Fire Marshal Division

Re: G & D Hauling
219 Jarco Drive
Fuquay Varina, NC 27526

Application Number BCOM1904-0002

1 LIFE SAFETY PLAN
SCALE: 1/8" = 1'-0"

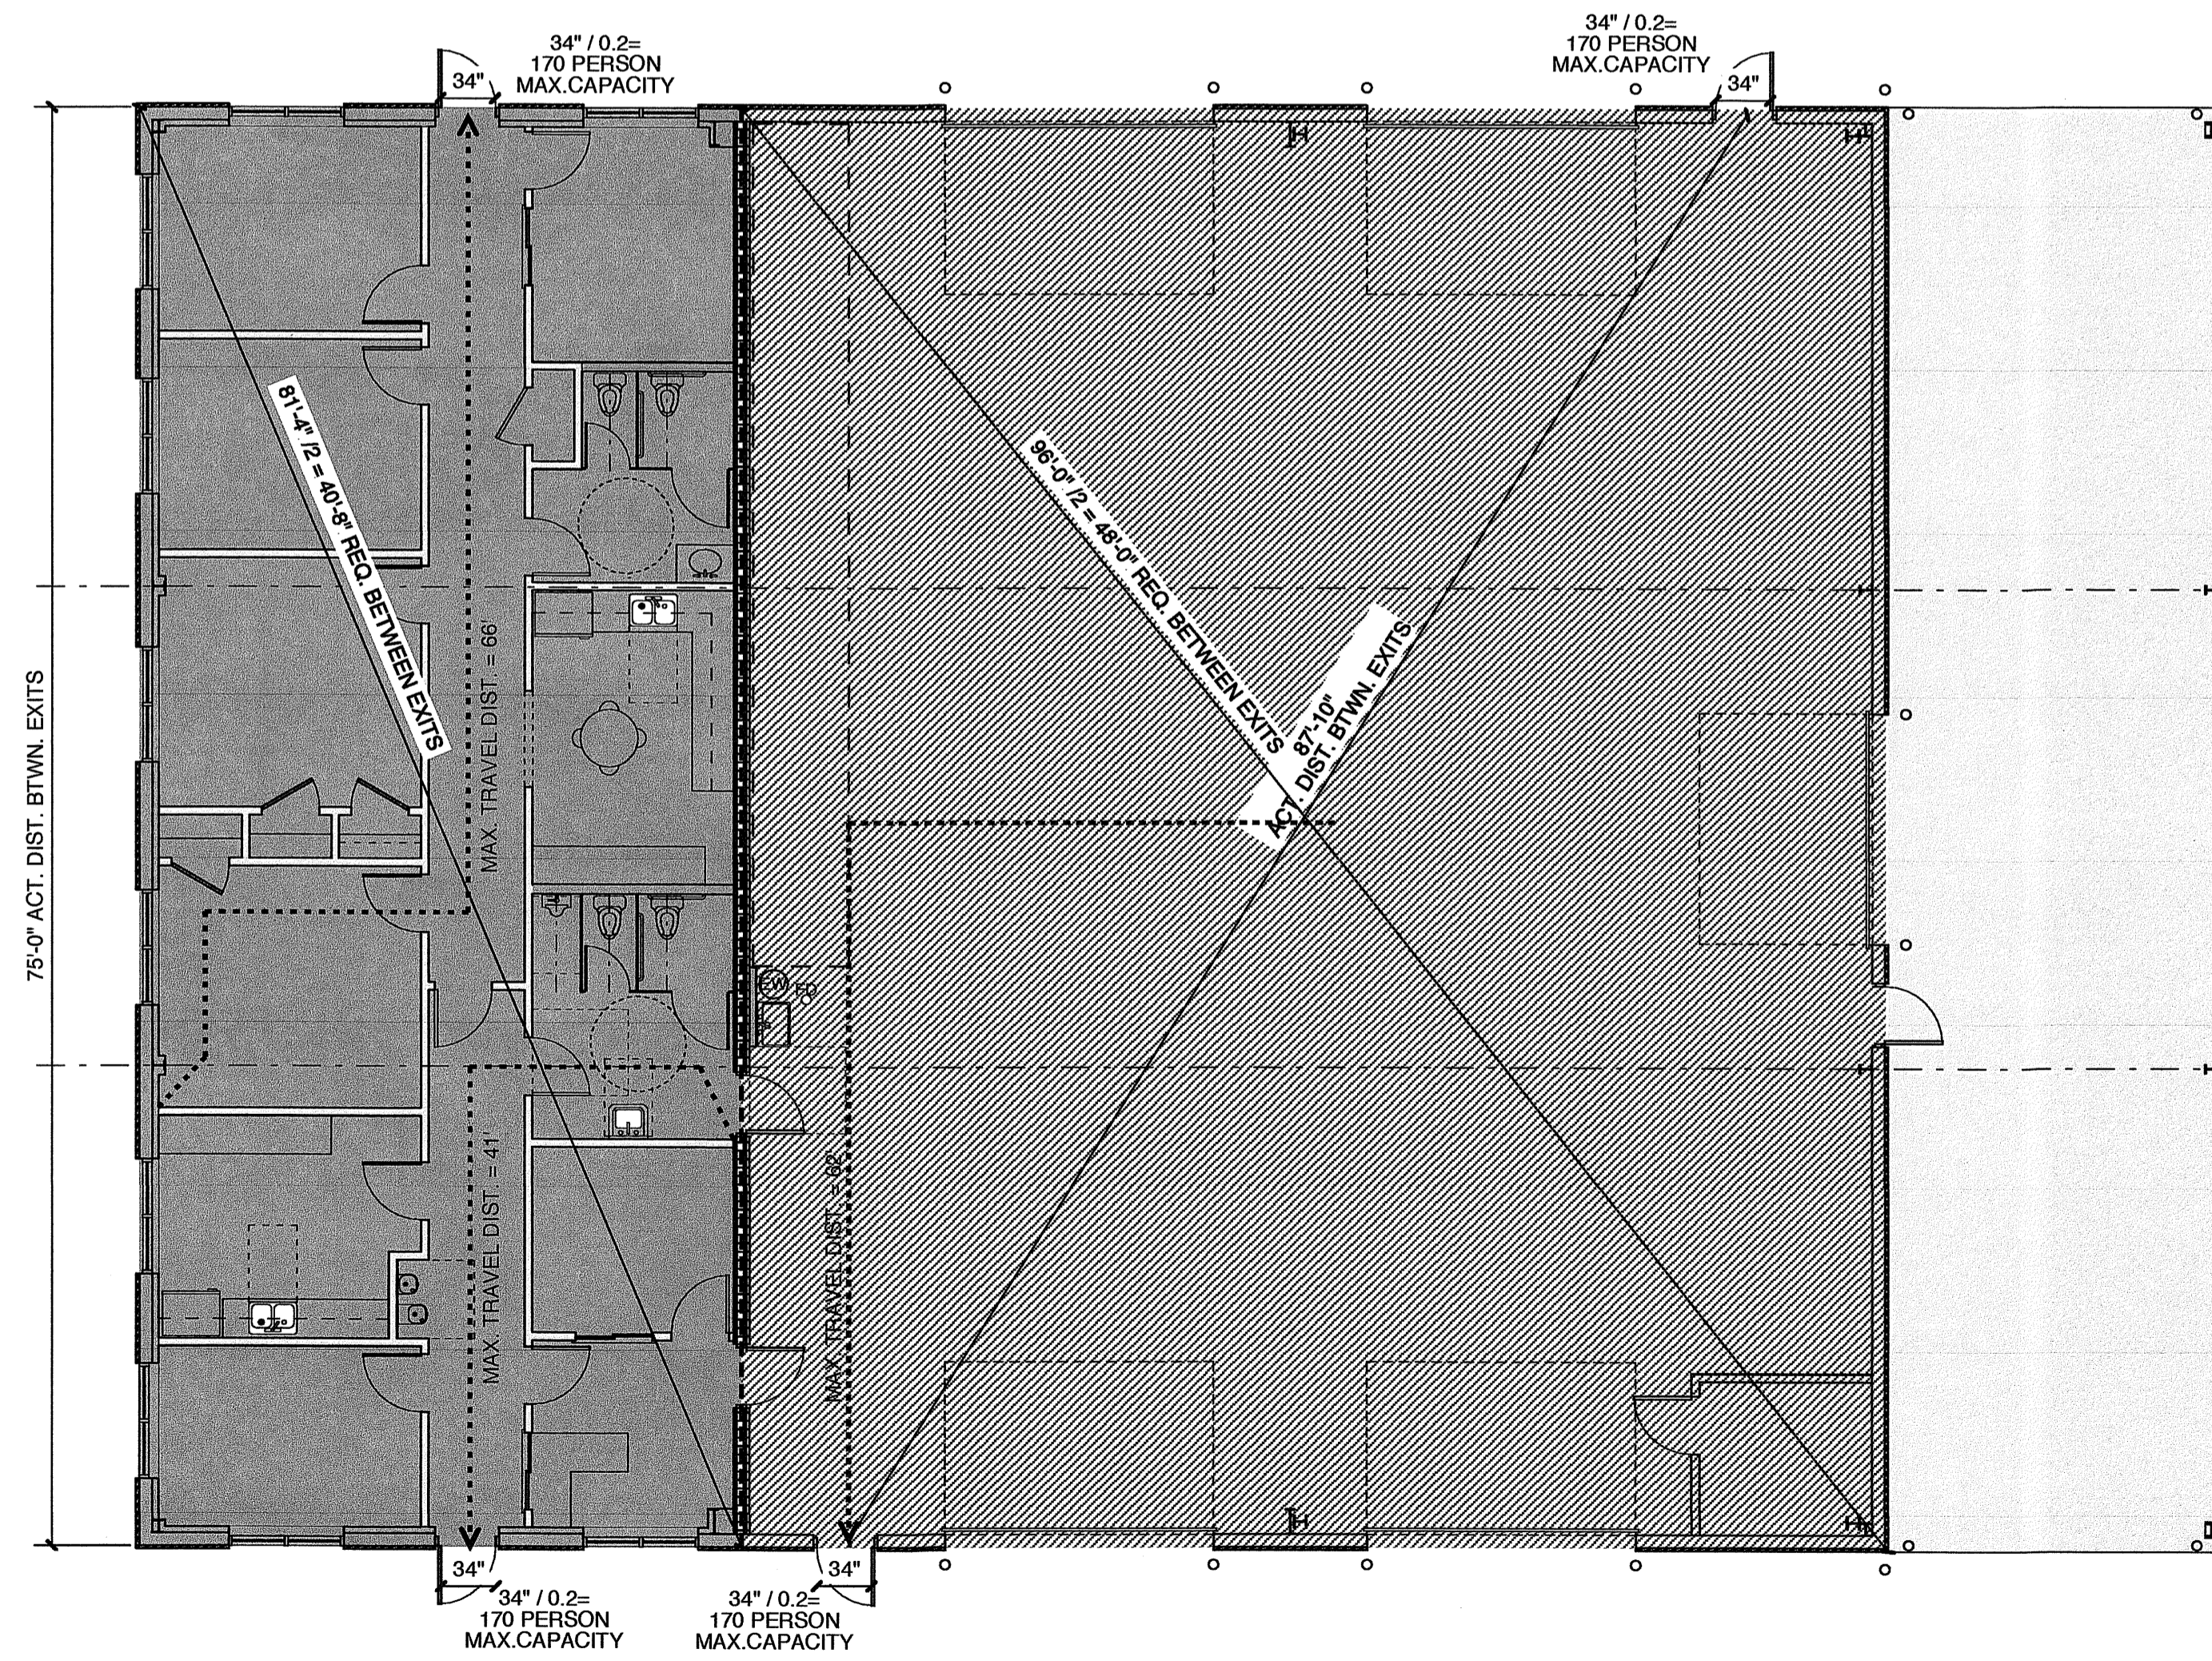
- **Fire Extinguishers**
 - Fire Extinguishers shall be 2A:20BC and shall be placed with a travel distance to not exceed 75'
 - Fire extinguishers are to be mounted no higher than 5' above the finished floor.

- **1006.1 Illumination Required**
 - The exit discharge shall be illuminated at all times the building spaces served by the means of egress is occupied
 - Illumination level in all areas of the means of egress shall not be less than 1 foot-candle at the walking surface and shall have emergency power supply.
